**Comments on
Written Representations
for the
Royal Society for the Protection of Birds
and Suffolk Wildlife Trust**

**Submitted for Deadline 5
23 July 2021**

**Application by NNB Generation Company (SZC) Limited for an Order
Granting Development Consent for
The Sizewell C Project**

**Planning Inspectorate Ref: EN010012
RSPB Registration Identification Ref: 20026628
Suffolk Wildlife Trust Registration Identification Ref: 20026359**

**Plate 1: Extract of Development Site showing bat activity**

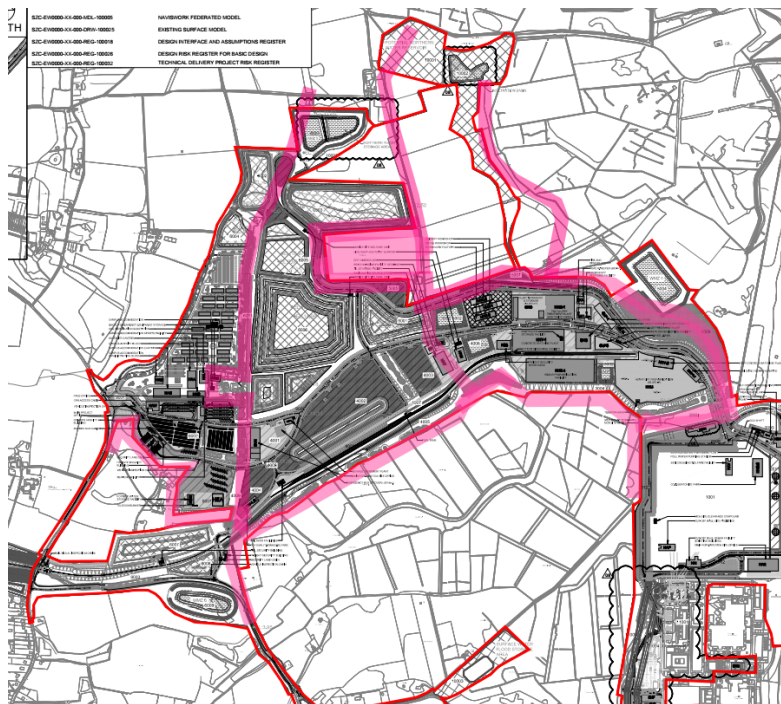
The RSPB and SWT Written Representation ² reference and concern	Applicant's Comments on Written Representations ³ reference and response	Comments from the RSPB and Suffolk Wildlife Trust
Statement for an Ecological Clerk of Works.		<ul style="list-style-type: none"> • The modelling is <u>indicative</u>. The comment in paragraph 2.7.1 is of significant concern since it makes clear that the Technical Note does not 'constitute detailed design'. We believe that detailed design is very much needed for potential effects to be considered. This uncertainty further compounds the uncertainty from the first bullet. • Paragraph 2.5.2 shows Bridleway 19 as well as Ash Wood, Ash Cottages and either side of WMZ 3 and 4 have a lighting buffer of only 10 metres. This isn't enough in our view, especially for Bridleway 19 as the buffer is taken from the centreline, so in reality, the actual buffer is considerably less. • There is clear spillage of 25 lux into Ash Wood indicating further mitigation is needed. • East of Ash Wood cottages and the flight line along the north of the site also looks like it might be over 25 lux, hence more mitigation is required. • We are concerned about the connectivity between Bridleway 19 and Kenton Hills as the dark area is intersected by the rail line. <p>The updated bat impact assessment¹¹ paragraph 4.1.4 notes - <i>the approach to maintenance of dark corridors at light levels below 1lux and evidence that this would be achievable is presented in Section 8.2.</i></p> <p>Paragraph 8.4.51 notes <i>Within the impact assessment for all bat species (Section 8.2), modelling that demonstrates that it will be possible to control the lighting impacts on key areas, extrapolated to other areas across the site is presented. This is the same for all bat</i></p>

The RSPB and SWT Written Representation ² reference and concern	Applicant's Comments on Written Representations ³ reference and response	Comments from the RSPB and Suffolk Wildlife Trust
		<p><i>species and shows that lux levels below 1lux can be achieved within sensitive areas across the site.</i> (emphasis added)</p> <p>We request measures to control light spill to below 1lux in all bat sensitive areas are provided and are secured through requirement 4.</p> <p>We have shared these concerns with the Applicant and will continue to discuss them further.</p> <p>Whilst we appreciate the Terrestrial Ecology Monitoring and Mitigation Plan does mention lighting (and are also aware this document will be updated for Deadline 5) currently there is no mention of lighting levels and therefore our concerns remain.</p> <p><u>Construction disturbance – noise</u></p> <p>The Applicant has submitted no new information.</p> <p><u>Sizewell Link Road</u></p> <p>The concerns detailed in our Written Representations submitted at Deadline 2¹² remain. We understand the Applicant will be submitting further information in response to our written representation at Deadline 5. We will review and comment when further information is submitted to the Examination.</p>
